From: Michael Eastham <Michael.Eastham@arun.gov.uk>
Sent: 22 September 2020 17:22
To: Planning.Responses <Planning.Responses@arun.gov.uk>
Subject: FW: BN/84/20/PL - Yapton Road, Barnham - Section 73 Layout

Please upload onto Ocella the email below which is a further consultation response from **ADC Drainage Engineers** to planning application **BN/84/20/PL** regarding Angels Nursery, Yapton Road, Barnham.

Subject: Re: BN/84/20/PL - Yapton Road, Barham - Section 73 Layout

Title
ATTENUATION TANK 1 DETAIL

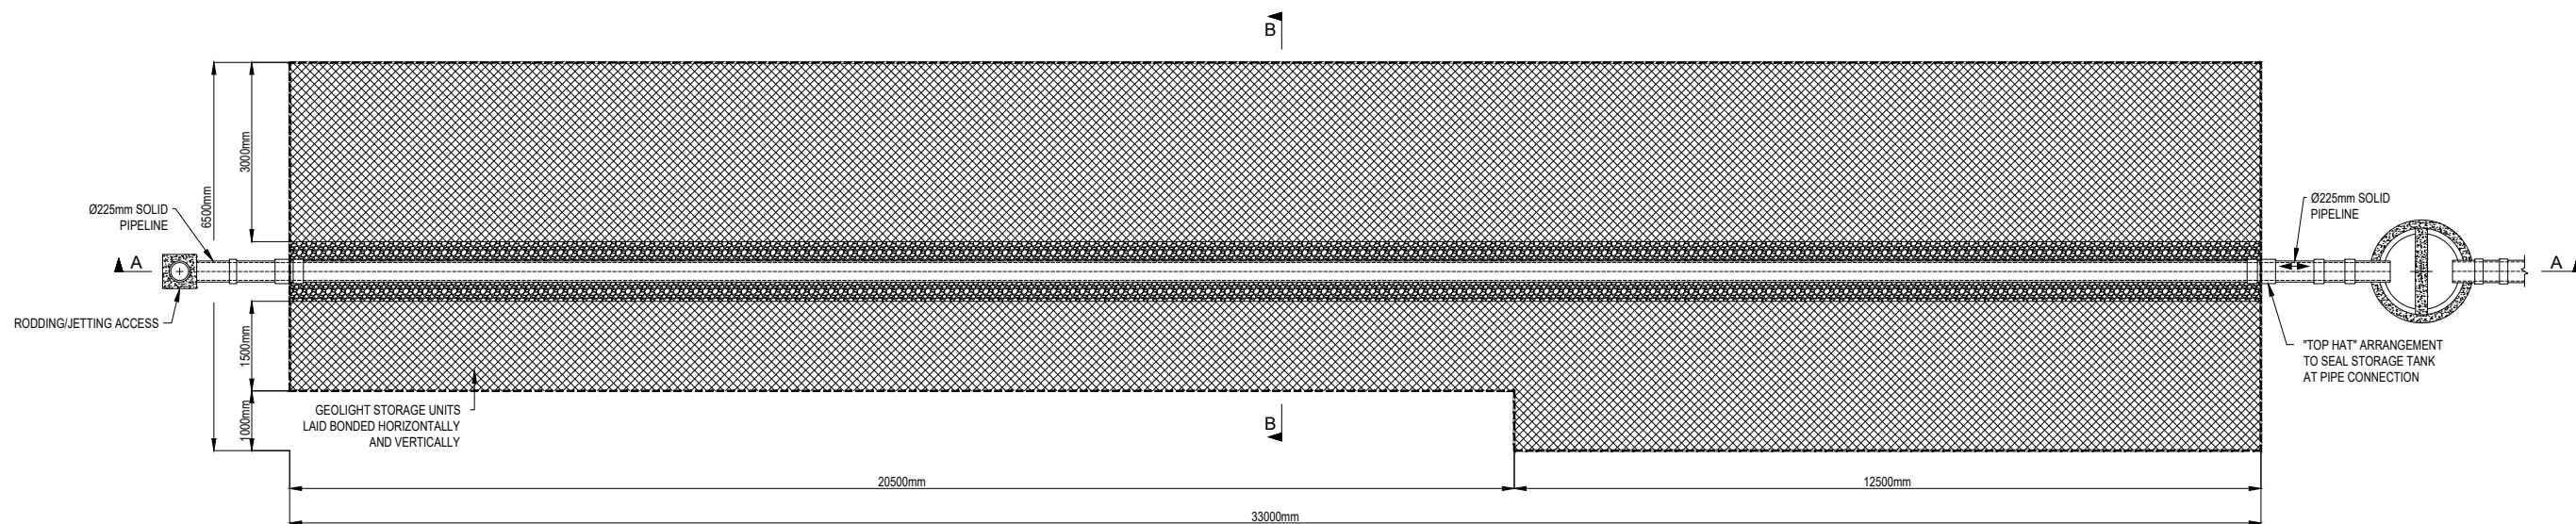
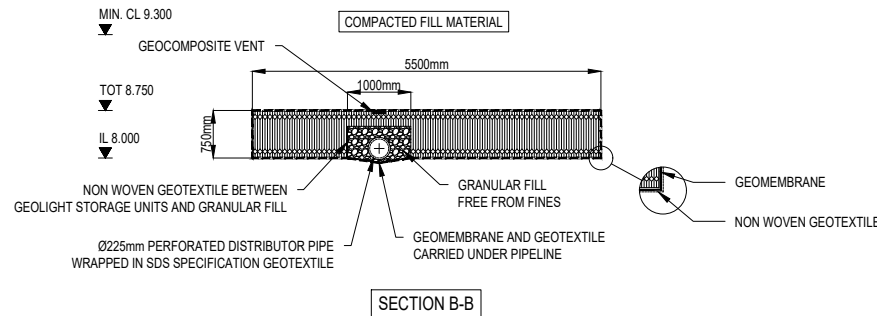
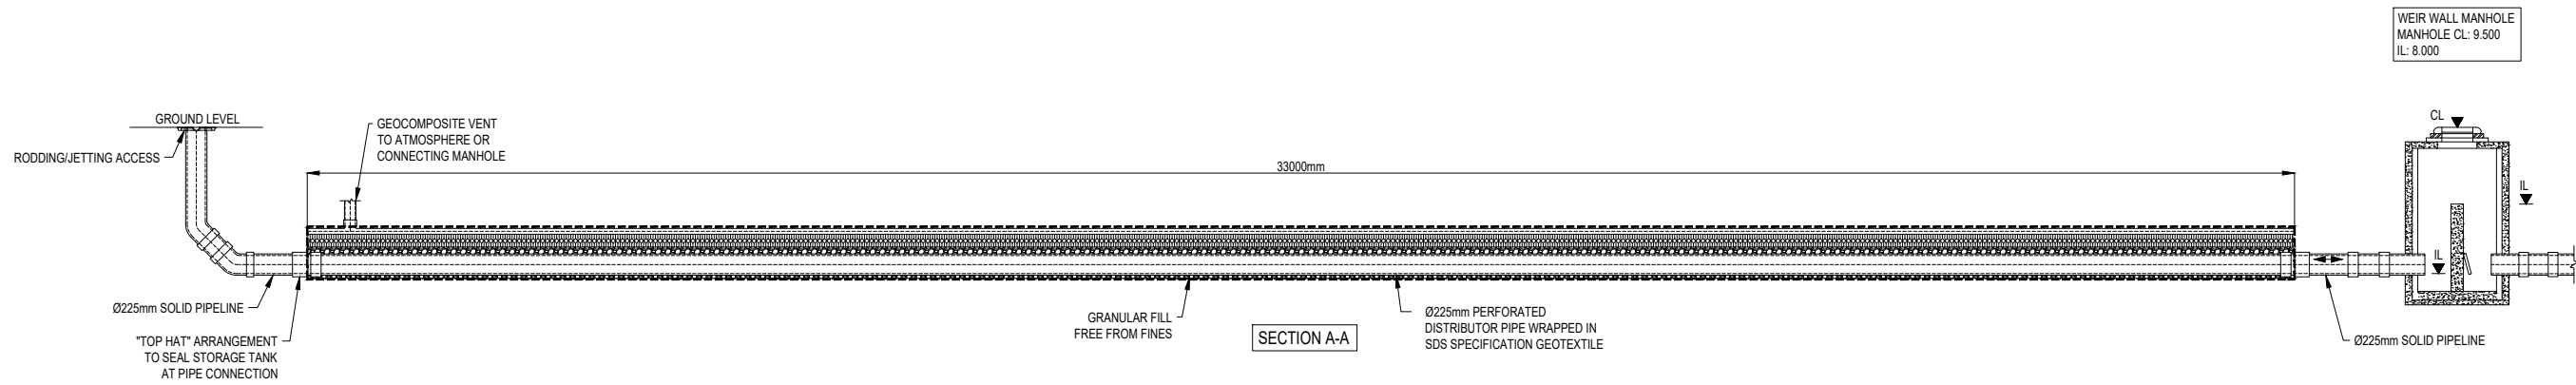
3. The proposed attenuation tank is offline. This is not suitable due to the risk of siltation in such a structure. Please provide an upstream connection for flush flow. An upstream connection cannot be made due to Southern Water requirements. However, the tank is now designed to be an SDS system with rodding access so that the system can be jetted through. *Please provide construction detail drawing.*

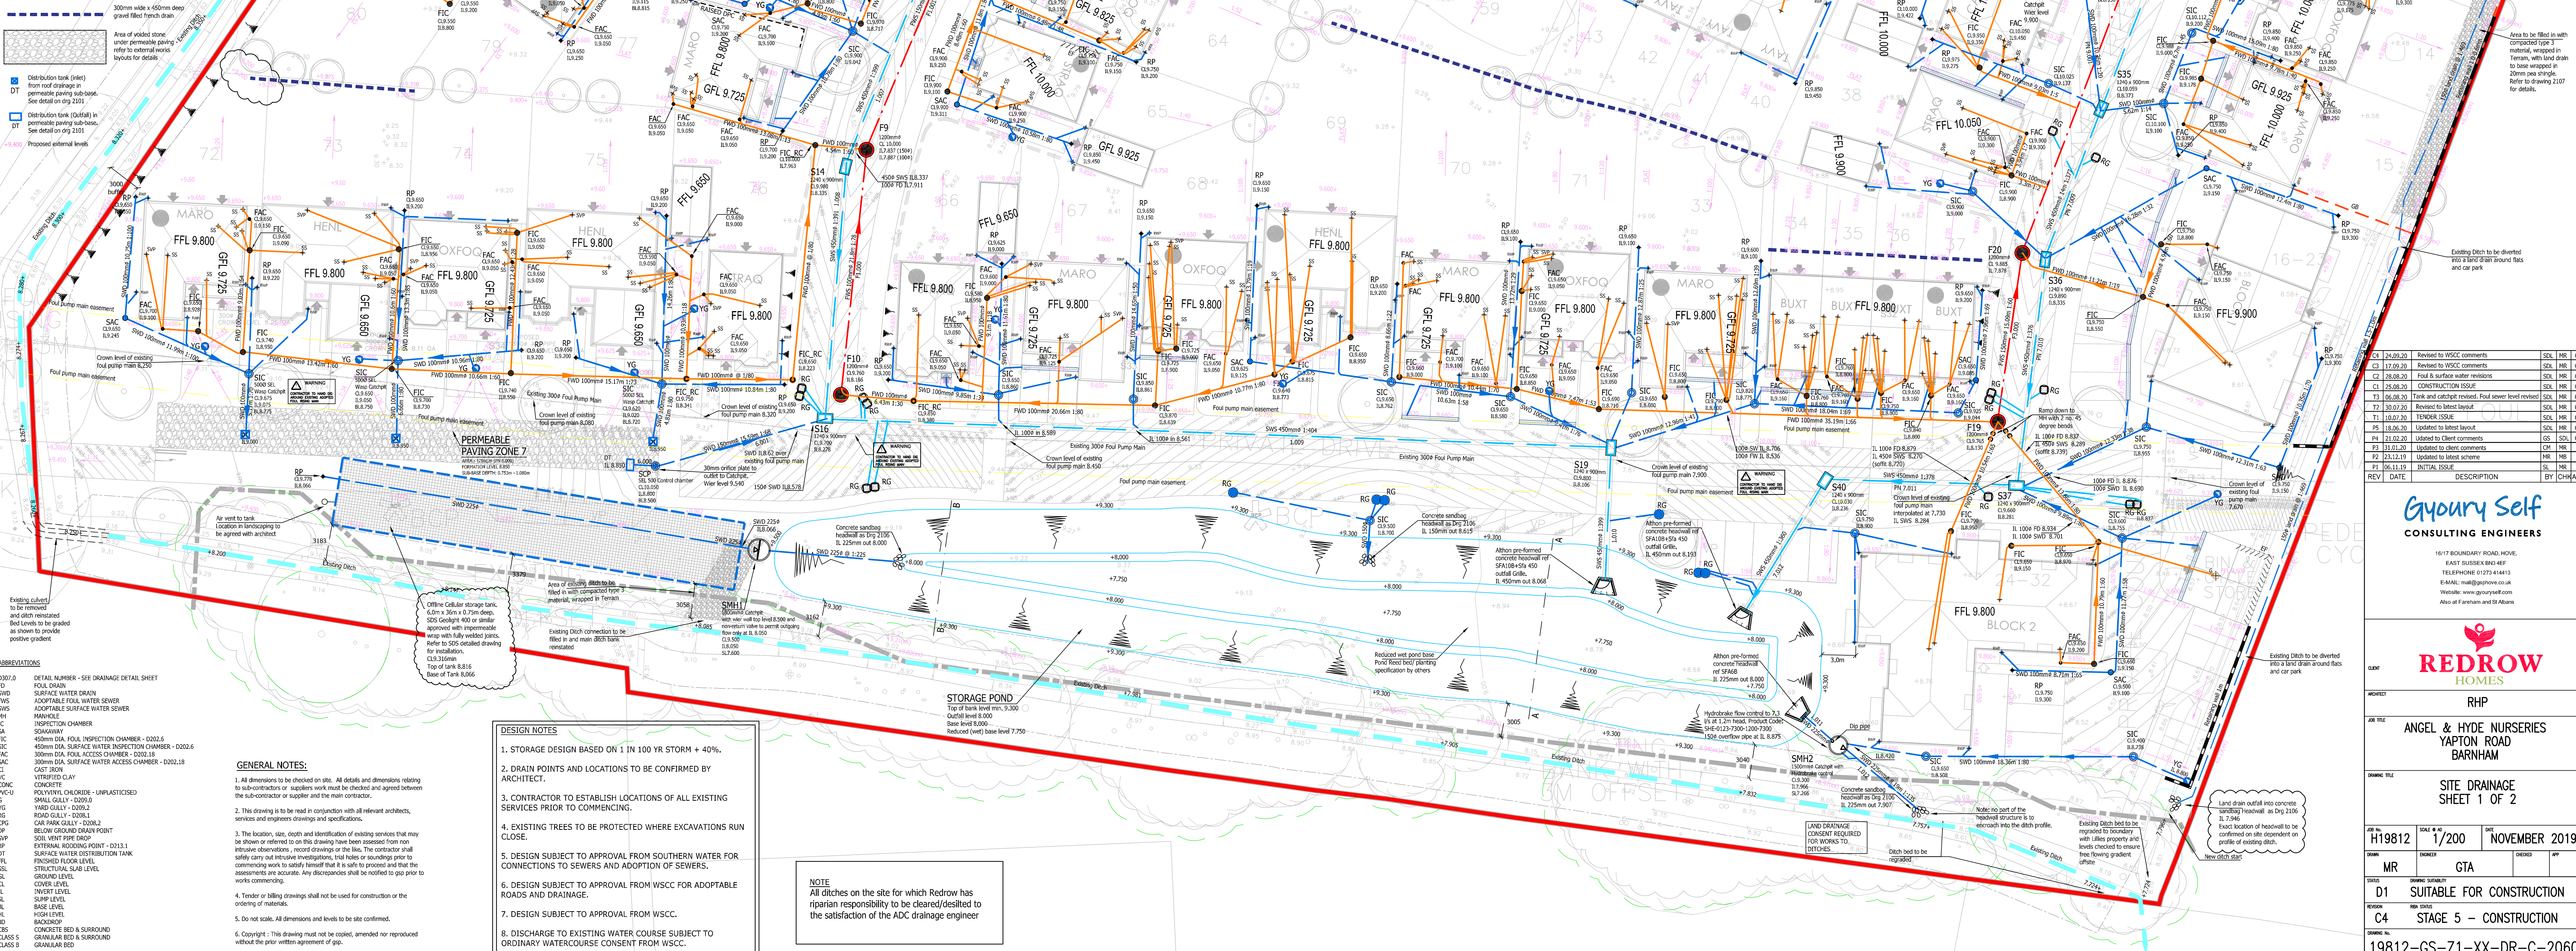
6. The revised plans indicate that further ditch infilling is proposed in the south western corner. This is not acceptable. There also appears to be insufficient room for the land drain. Do you mean the south east corner ? The existing ditch is culverted due to the layout of the flats and the car park and link path. Without changing the parking and flats layout I can't see how we can maintain the existing ditch here. Paul Cann agreed to filling of this ditch as it doesn't serve anything to the east -- the only difference between the consented scheme is the filling in of the ditch is slightly longer -- about 15m longer. *Discussed with Paul Cann, okay to infill. However, new/ revised consent required.*

7. The land drain is shown to connect into the surface water network, prior to the flow control device. This is not acceptable, groundwater flows have not been accounted for in design. Please remove this and revise proposals to be as per the previously approved scheme, i.e. section of ditch in the south western corner to remain and land drain to feed into the head of this. Do you mean the South east corner ? The land drain isn't connected into the new surface water system. The land drain outfalls back into the open ditch as shown on the layout. *Apologies, south eastern corner. The land drain connects against the direction of flow, please correct. The headwall also does not appear to be at the correct location, i.e. it isn't within the ditch.*

11. Please provide an mdx of the calculations to facilitate review. See enclosed. *Permeable paving area 2 is modelled with a very different invert level to that shown on plan. Please correct. Cellular storage crate has been modelled as 0.8m deep, yet now proposed to be 0.75m. Please revise. It is also unclear how you have modelled the weir arrangement between the two storage devices.*

12. The point of connection from the basin to the ditch appears to have changed. A new land drainage consent, or alterations to the existing will be required. *Noted. Awaited.*

are these features being proposed? French drains at low points of back gardens are proposed to improve land drainage in gardens, to prevent saturated topsoil. These are not connected to the surface water system or ditch. *The drain to the rear of 72-80 appears to terminate at the ditch. Please revise the extent or submit land drainage consent.*

16. The trees indicated on the drainage plans do not tally with those shown on the landscaping plans. No trees should be located over/ within the pond or tank area. Proposed trees have been removed from the pond area. *There appears to be a tree proposed near the tank very close to SMH1, please remove. Please confirm if landscaping proposals have been adjusted.*
